Lake House – Corrections Response Letter

Building Plan Reviewer: **City of Mercer Island**

Response to: 2012-200 Lorenzini Remodel 2R
Dated: June 17, 2021
Permit #: 2012-200
Project address: 3310 97th Ave SE
Mercer Island, WA 98040

Re: *Lorenzini Remodel (Lake House) at 3310 97th Ave SE Permit No. 2012-200*

1 MAIN FLOOR FRAMING PLAN
 1/4" = 1'-0"

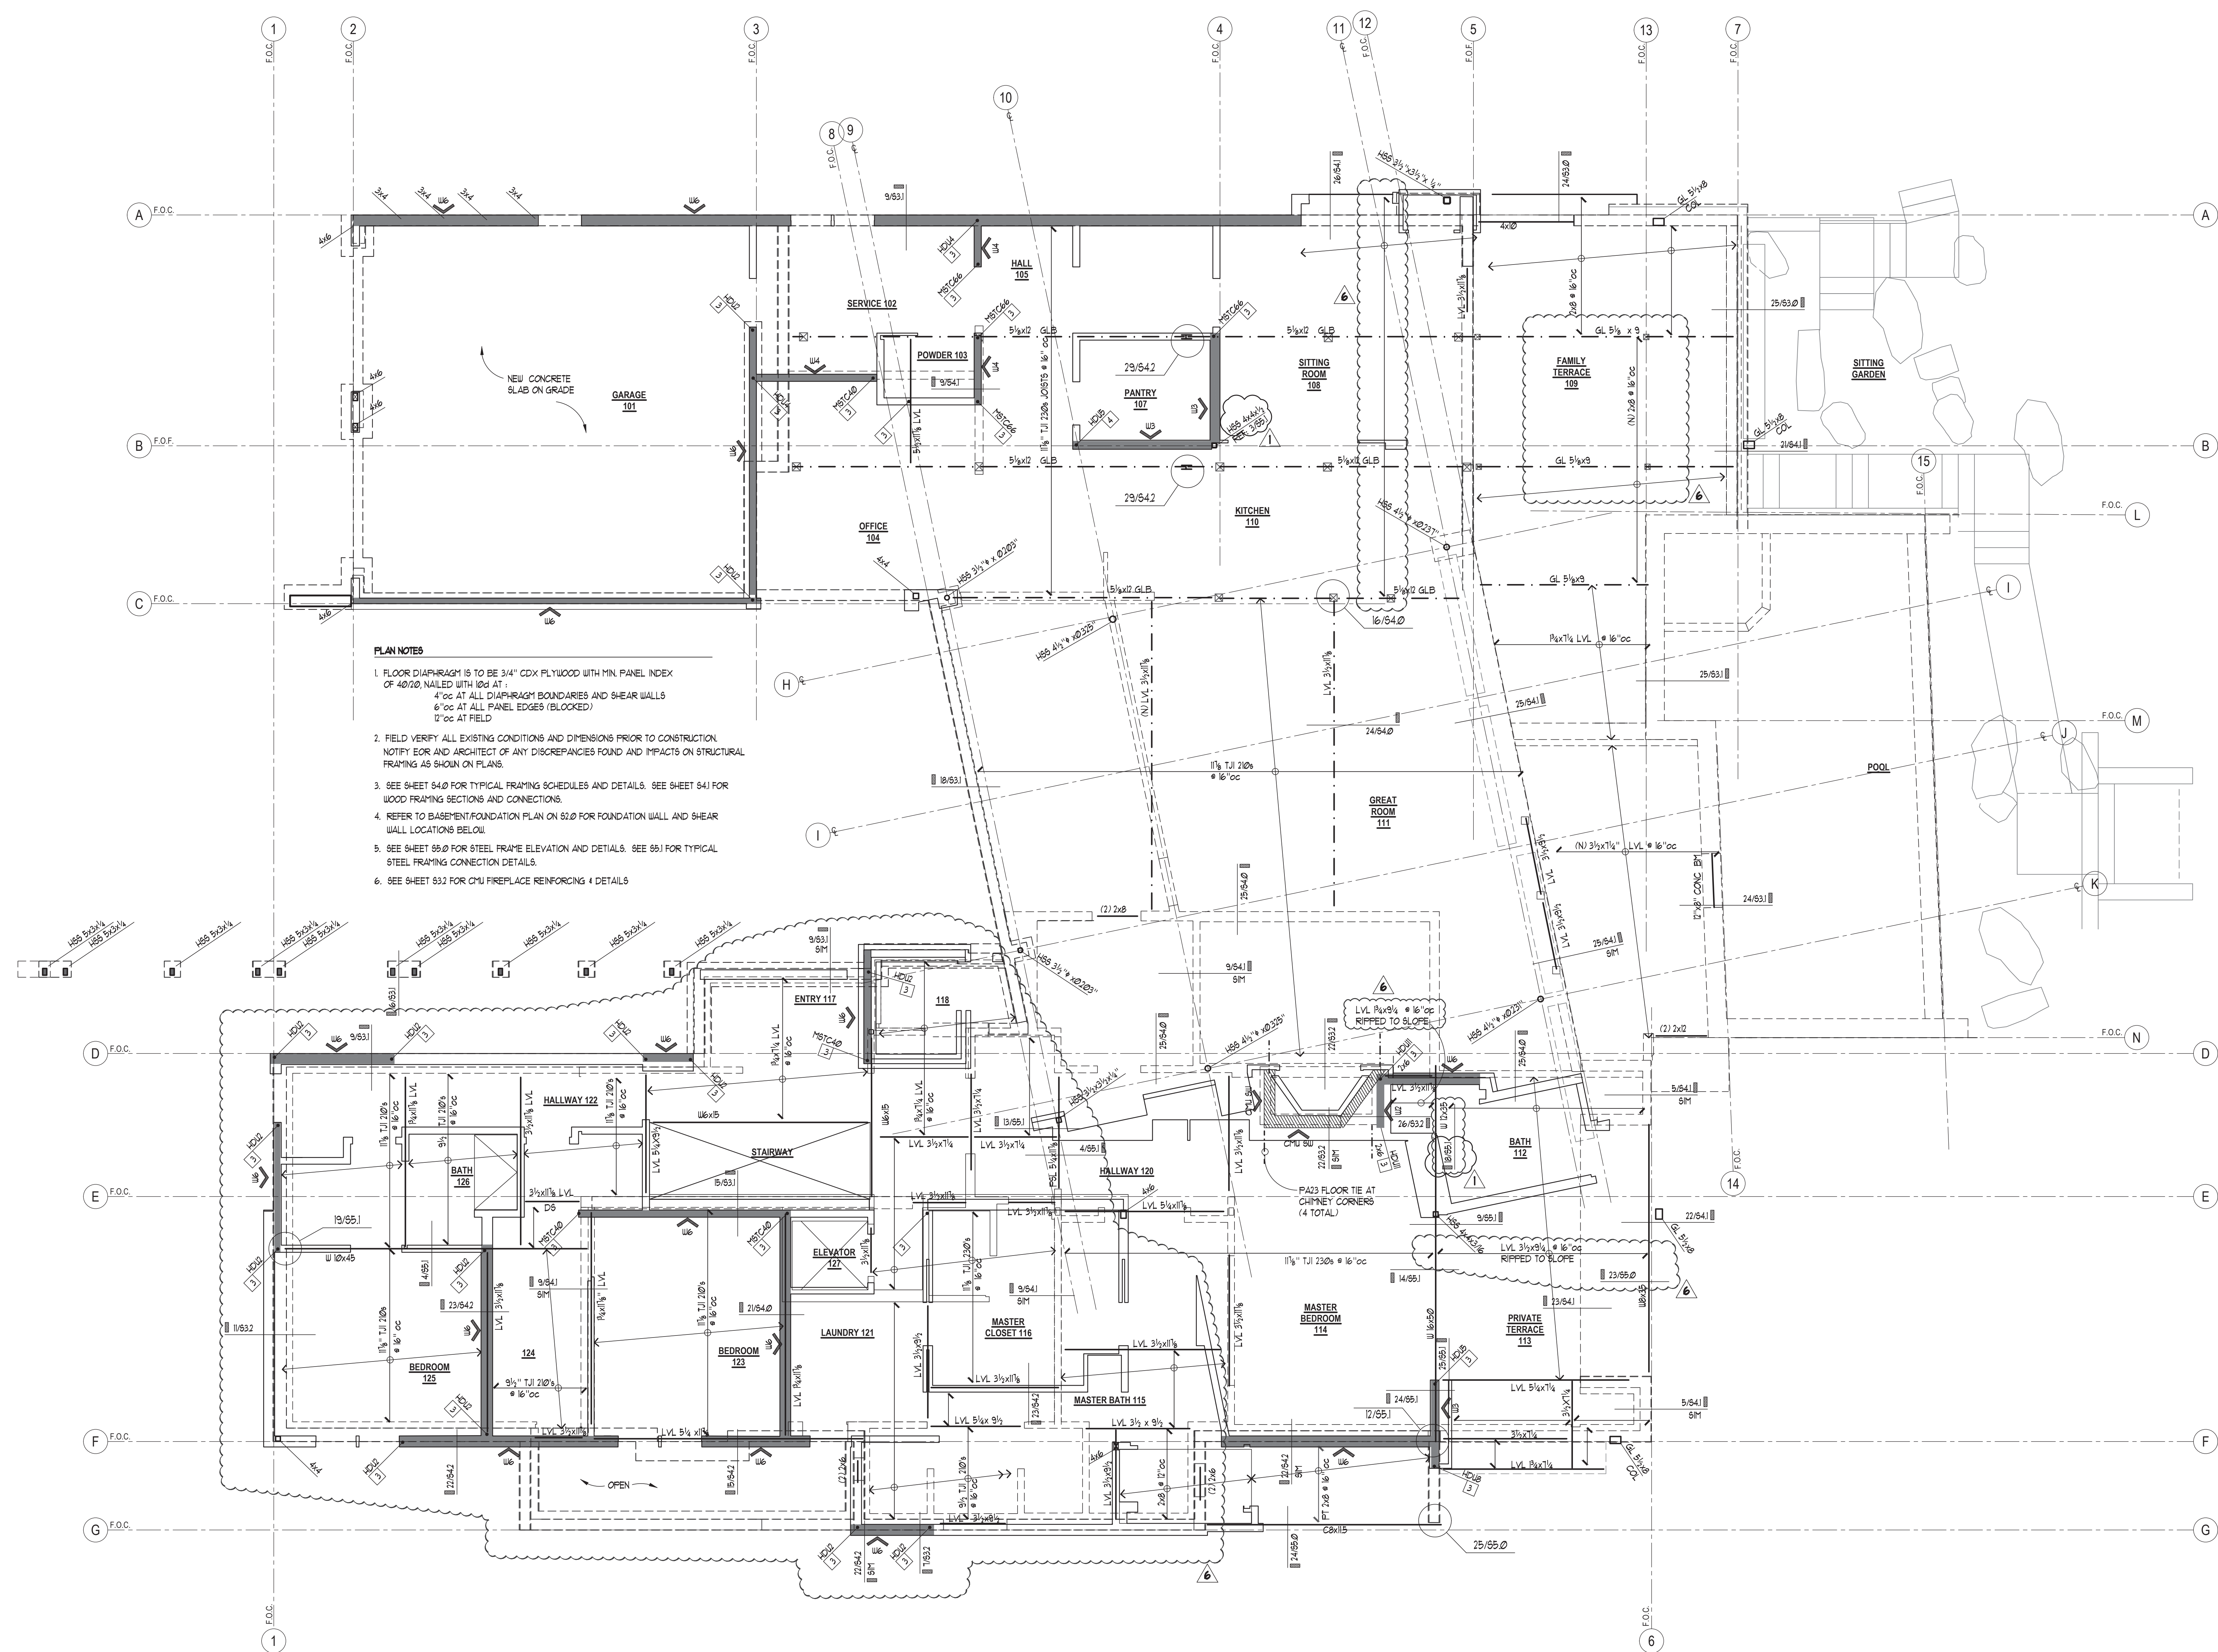
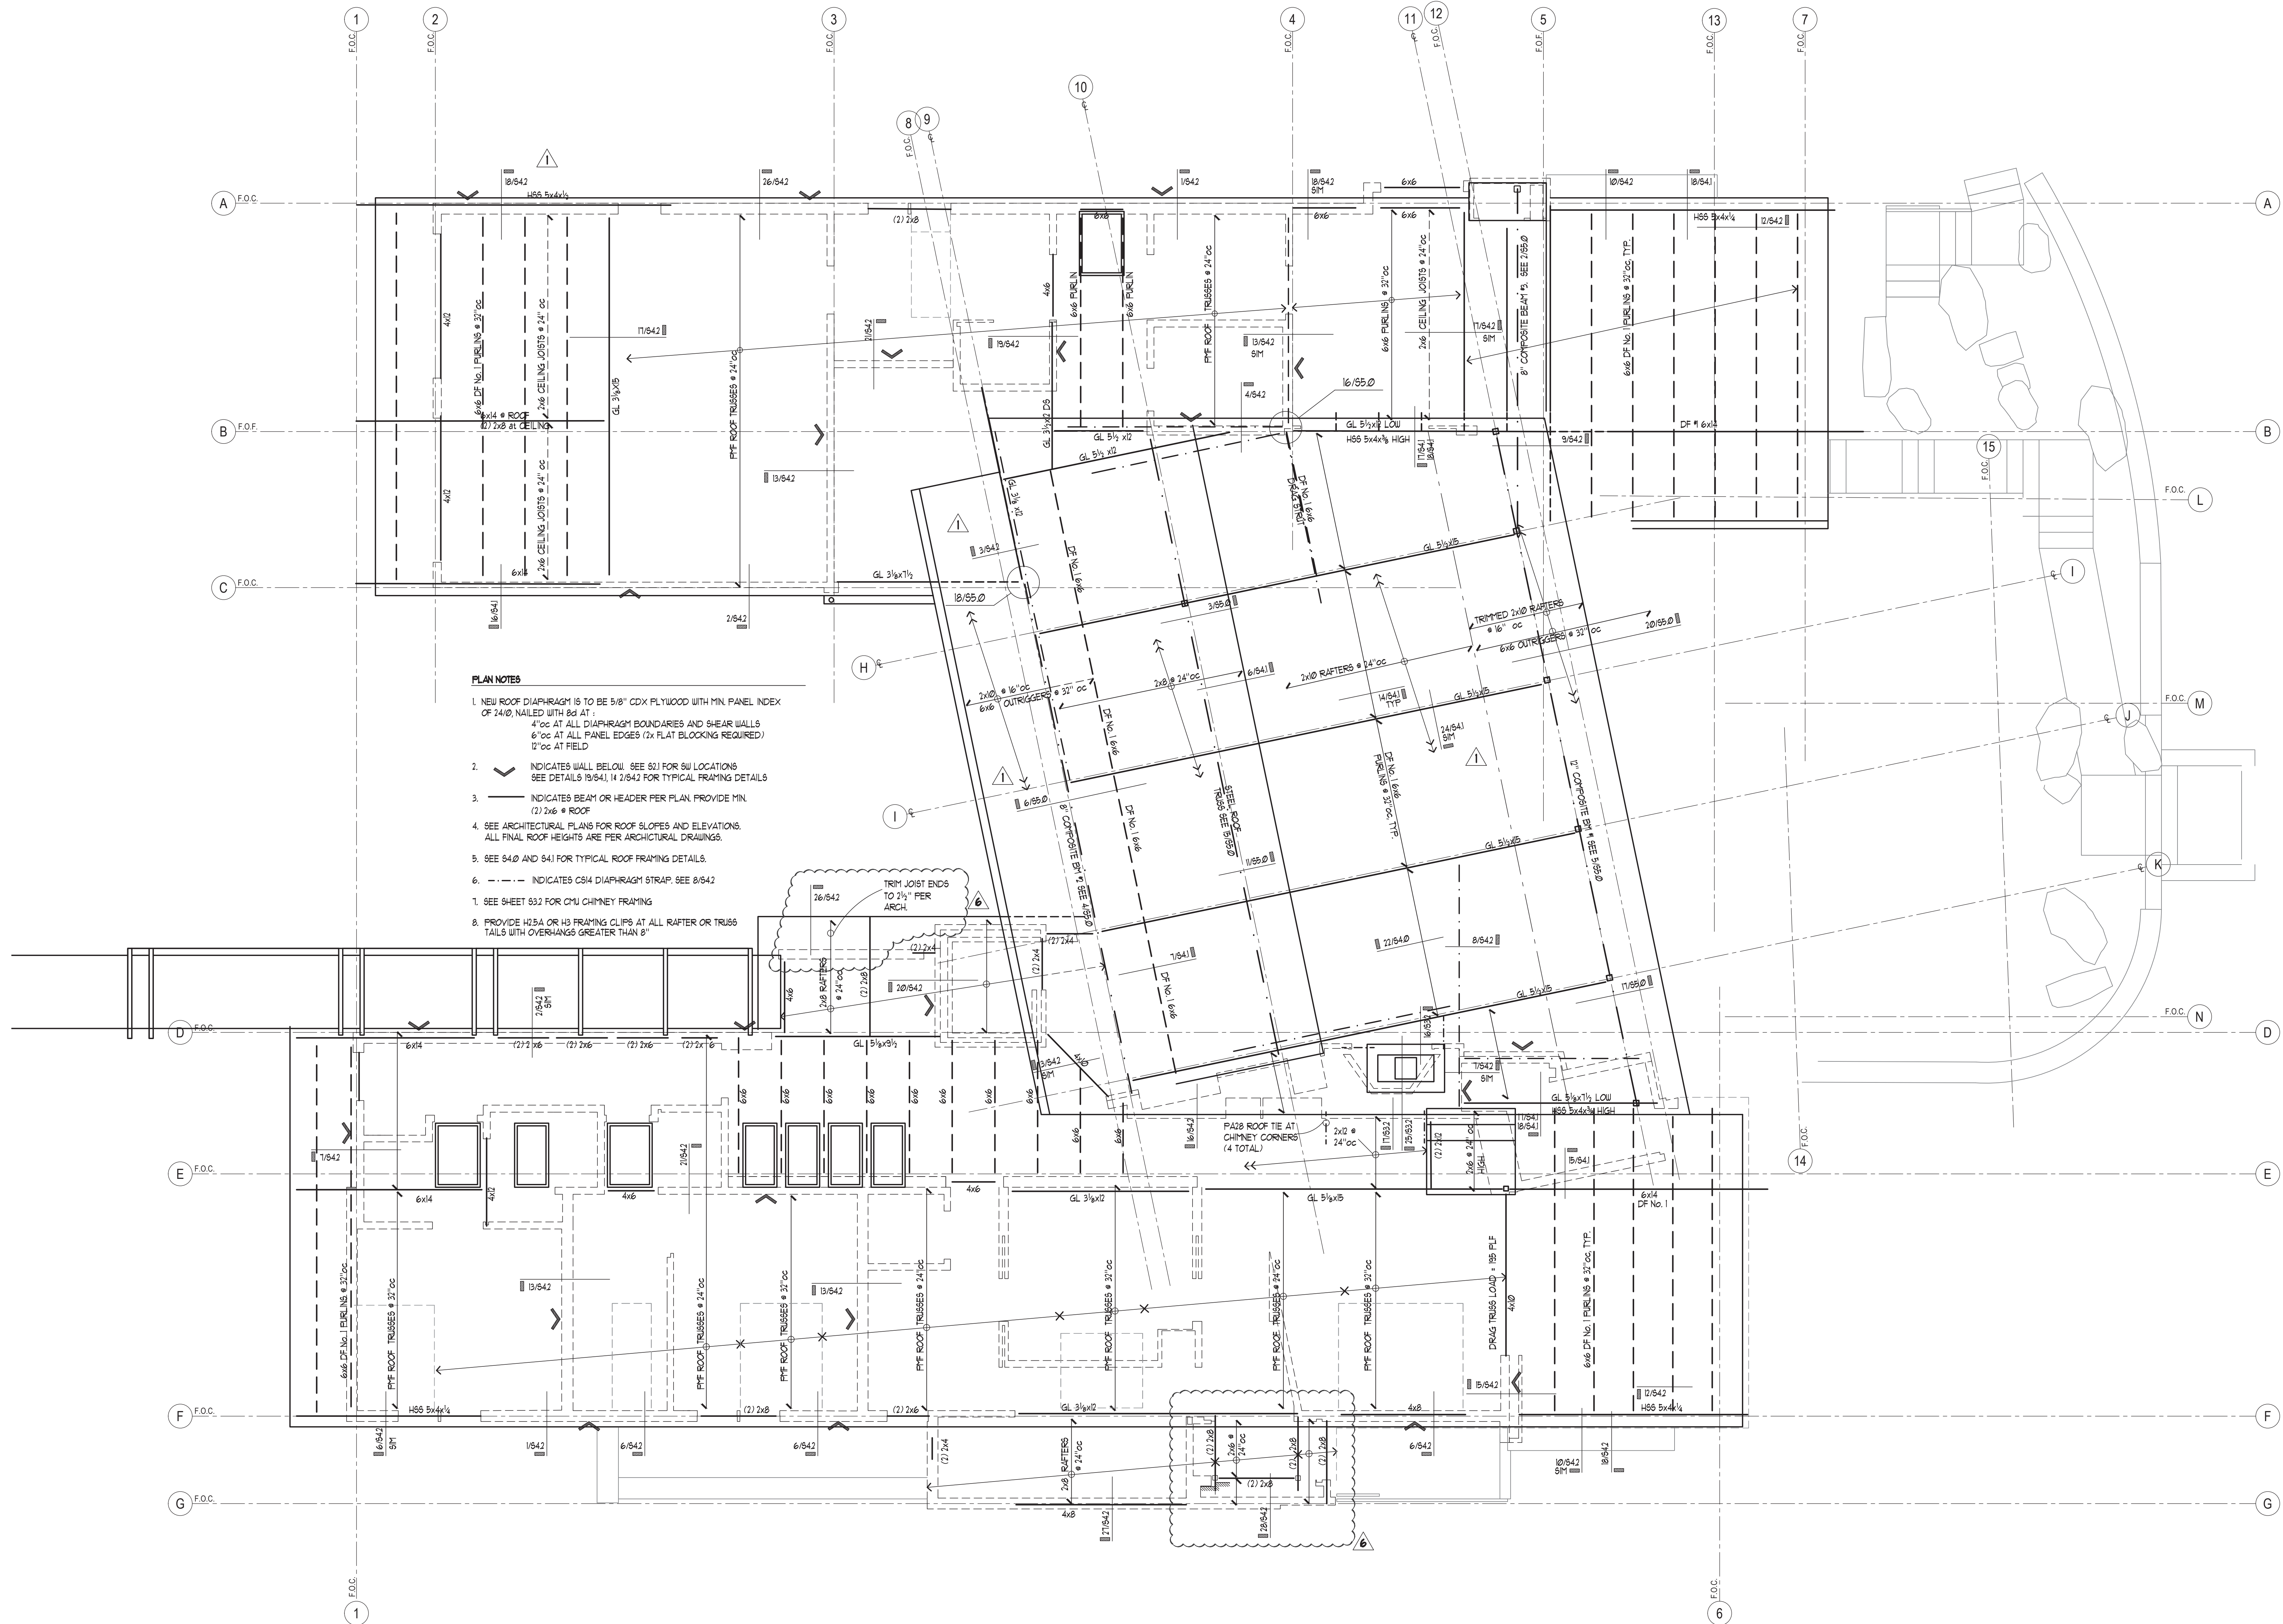
8. A new WF beam is added on Sheet S2.1 between Hallway 122 and Bedroom 125. Detail 4/S5.0 is cut on the Main Floor Framing Plan; should this be Detail 4/S5.1?
Yes, the detail callout has been corrected to 4/S5.1

9. Please call out the existing joists at the west wing, Sheet S2.1, where the span symbol is showing between Grids 3-4 & A & C.
A callout specifying the existing joists in this wing has been added to the floor plans.

- a. The HHS column serves as a holdown for both Type C & N shear walls at the upper level. Please reference Detail 3/S5.1 on Sheet S2.1 at this location to clarify connection to the column, assuming that is the intended reference.

- a. A holdown appears to be missing from the upper floor short wall segment, Sheet S2.1.

Detail 3/S5.1 is referenced in 16/S5.0, the detail showing the section through the column at the corner. An additional reference has been added on sheet S2.1 at the column location.

An additional HDU2 callout has been added to S2.1
